From: Colin Graham <c.graham@dorsetcc.gov.uk>
Sent: 19 January 2021 16:59
To: Robert Piggot
Subject: RE: Planning Consultation WP/20/00854/FUL 1 CHURCHILL CLOSE, WEYMOUTH, DT4 9LZ

Highway Authority Recommendation

RE: Planning Consultation WP/20/00854/FUL 1 CHURCHILL CLOSE, WEYMOUTH, DT4 9LZ

**PROPOSED
VEHICULAR ACCESS AND DROPPED KERB
AT: No 1 CHURCHILL CLOSE,
WYKE REGIS, WEYMOUTH,
DORSET.
DT4 9LZ.**

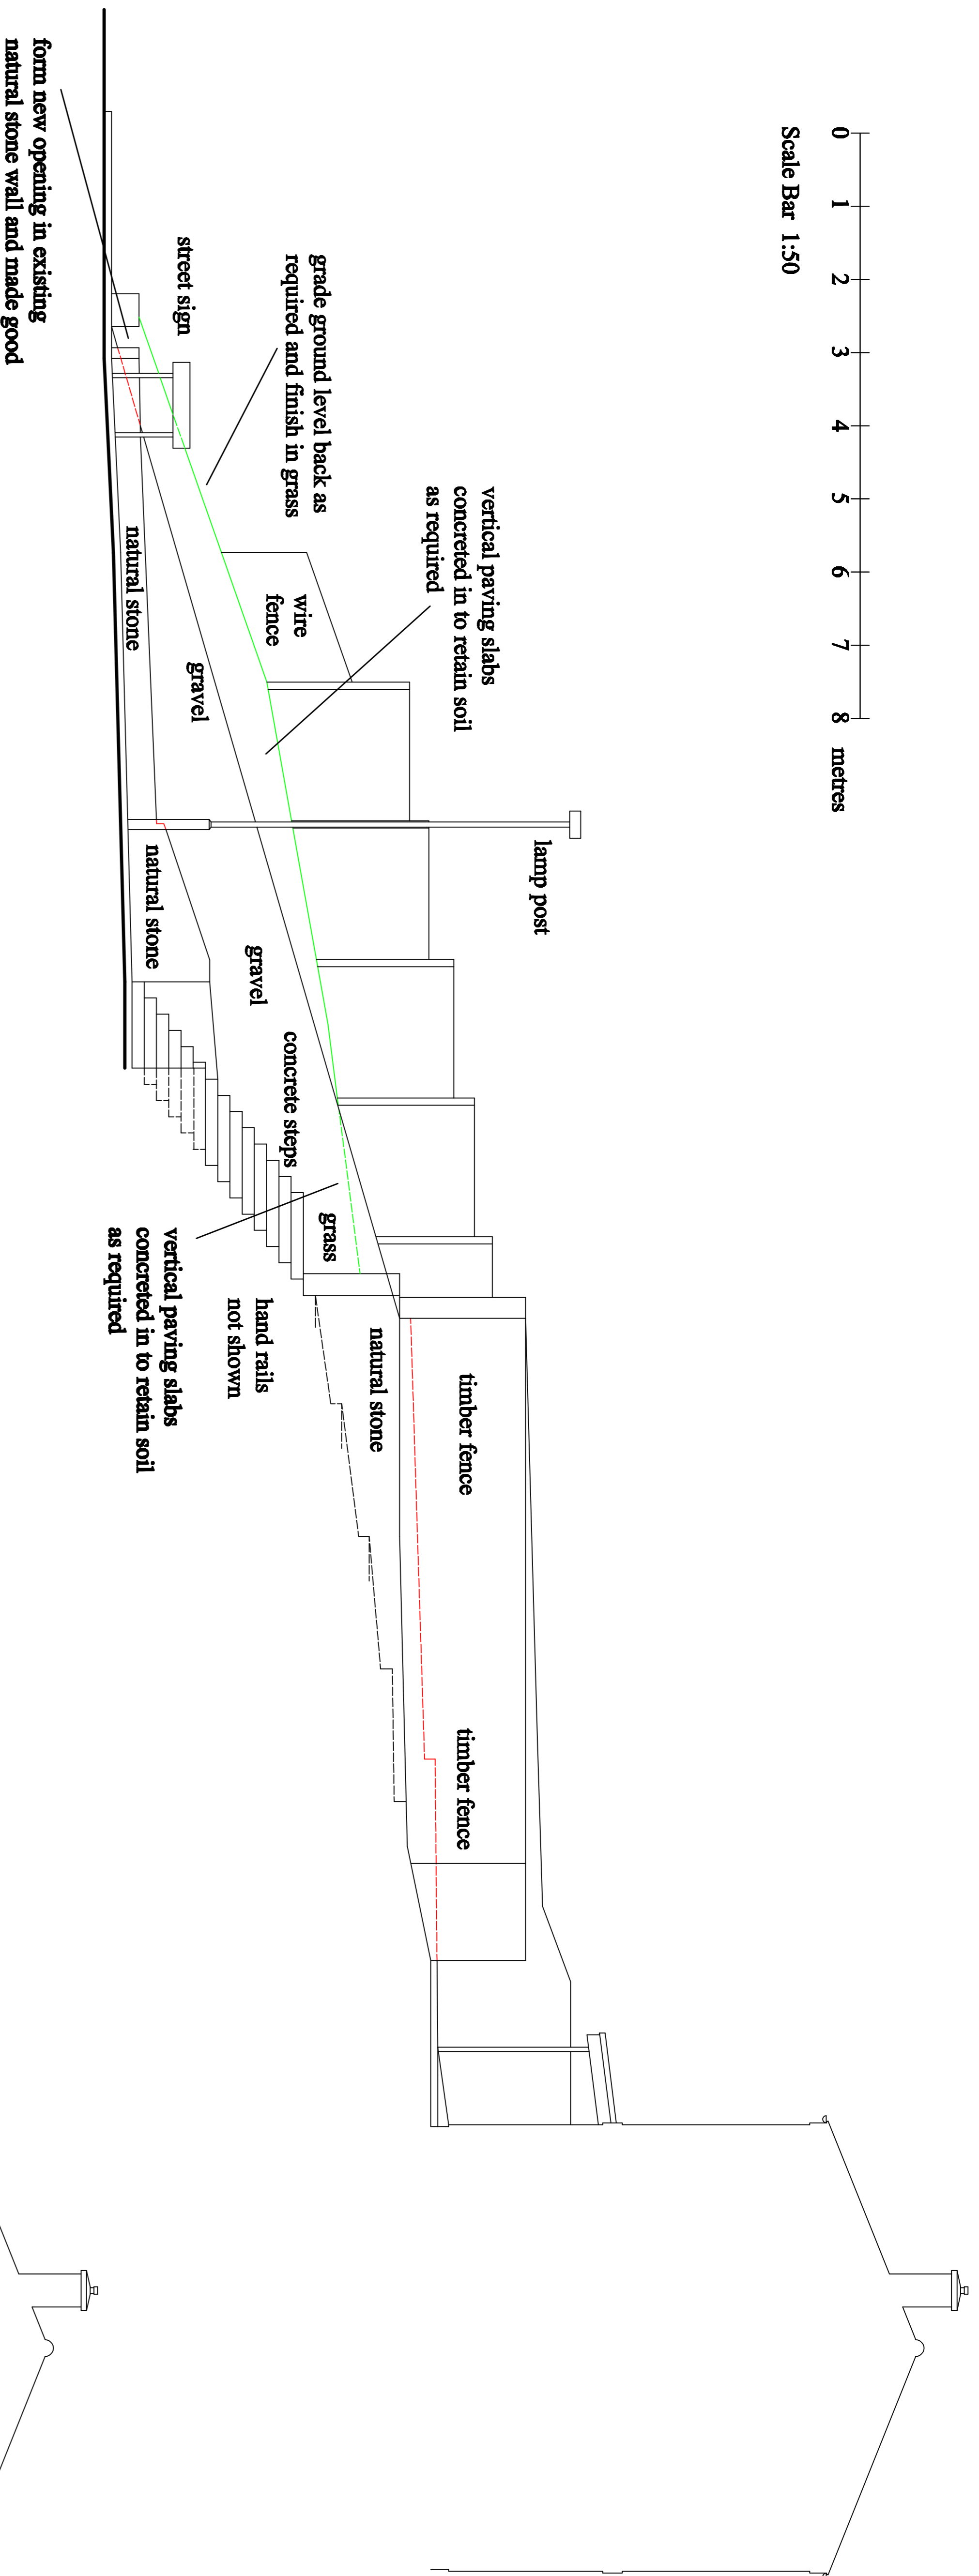
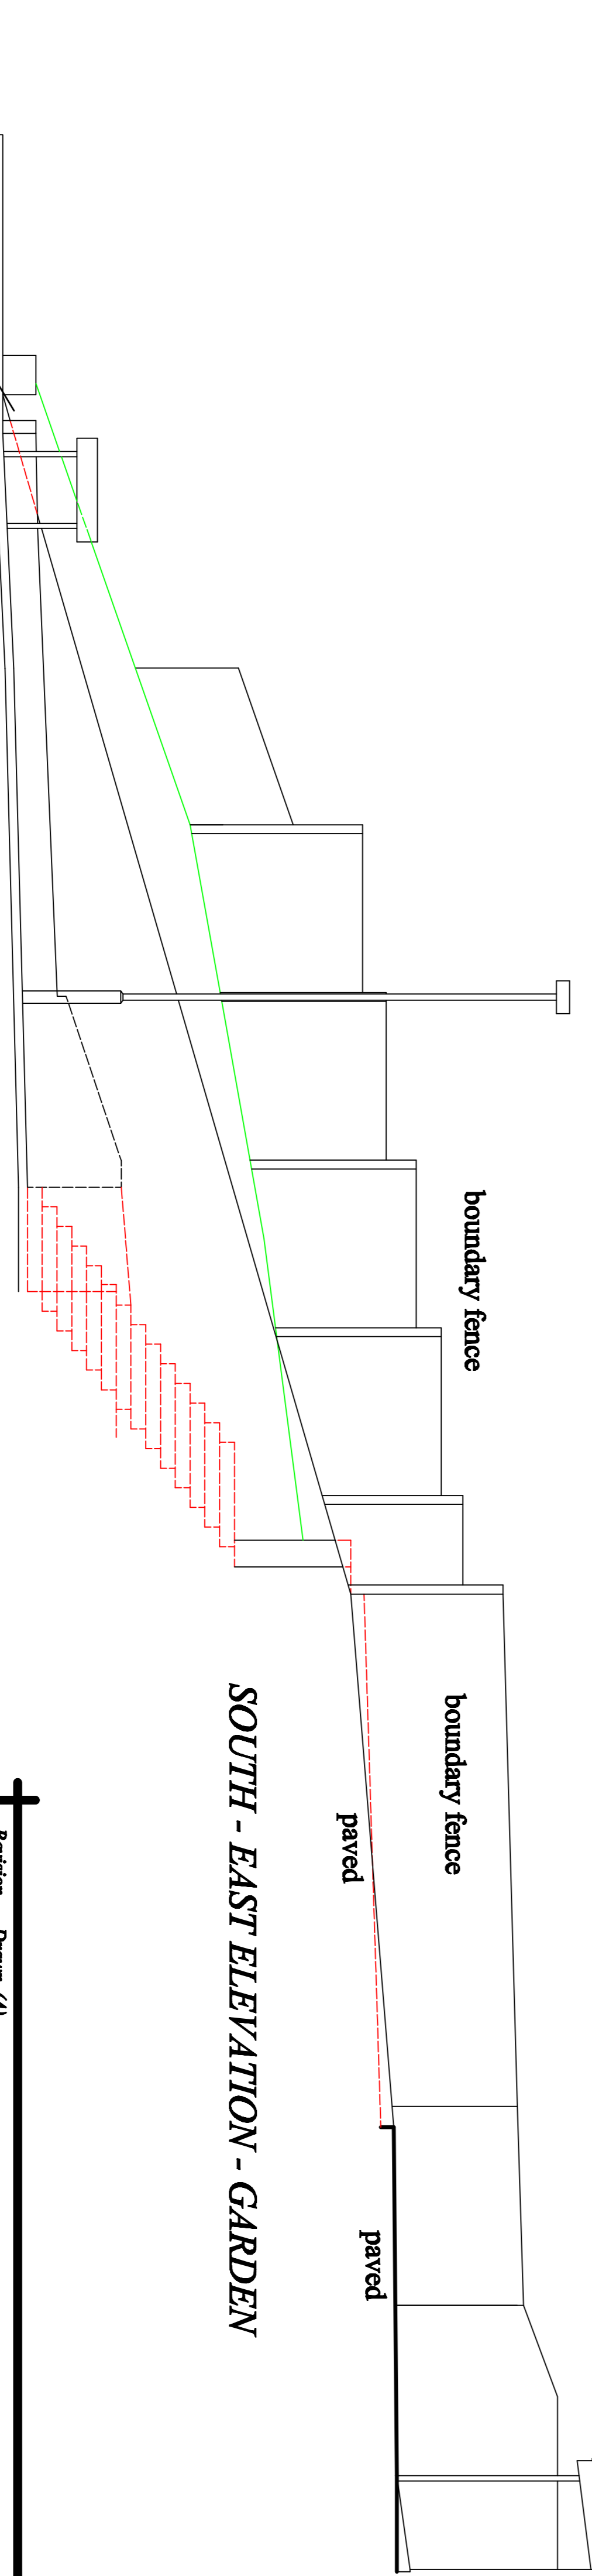
The Highway Authority considers that in this particular and unusual situation the proposals do not present a material harm to the transport network or to highway safety. It is sufficiently distant from the “whole in the wall”, through which speeds are understandably slow with good visibility through it and of the other adjacent roads. The footway on this side takes very little, if any, pedestrian movements the other side of the road being favoured especially as it links to the school, consequently the highway authority has NO OBJECTION subject to the following conditions:

Before the development is occupied or utilised the first 5 metres of the vehicle access, measured from the rear edge of the highway (excluding the vehicle crossing – see the **Informative Note** below), must be laid out and constructed to a specification submitted to and approved in writing by the Local Planning Authority.

The vehicle crossing serving this proposal (that is, the area of highway land between the nearside carriageway edge and the site’s road boundary) must be constructed to the specification of the Highway Authority in order to comply with **Section 184 of the Highways Act 1980**. The applicant should contact Dorset Highways by telephone at 01305 221020, by email at dorsethighways@dorsetcouncil.gov.uk, or in writing at Dorset Highways, Dorset Council, County Hall, Dorchester, DT1 1XJ, before the commencement of any works on or adjacent to the public highway.
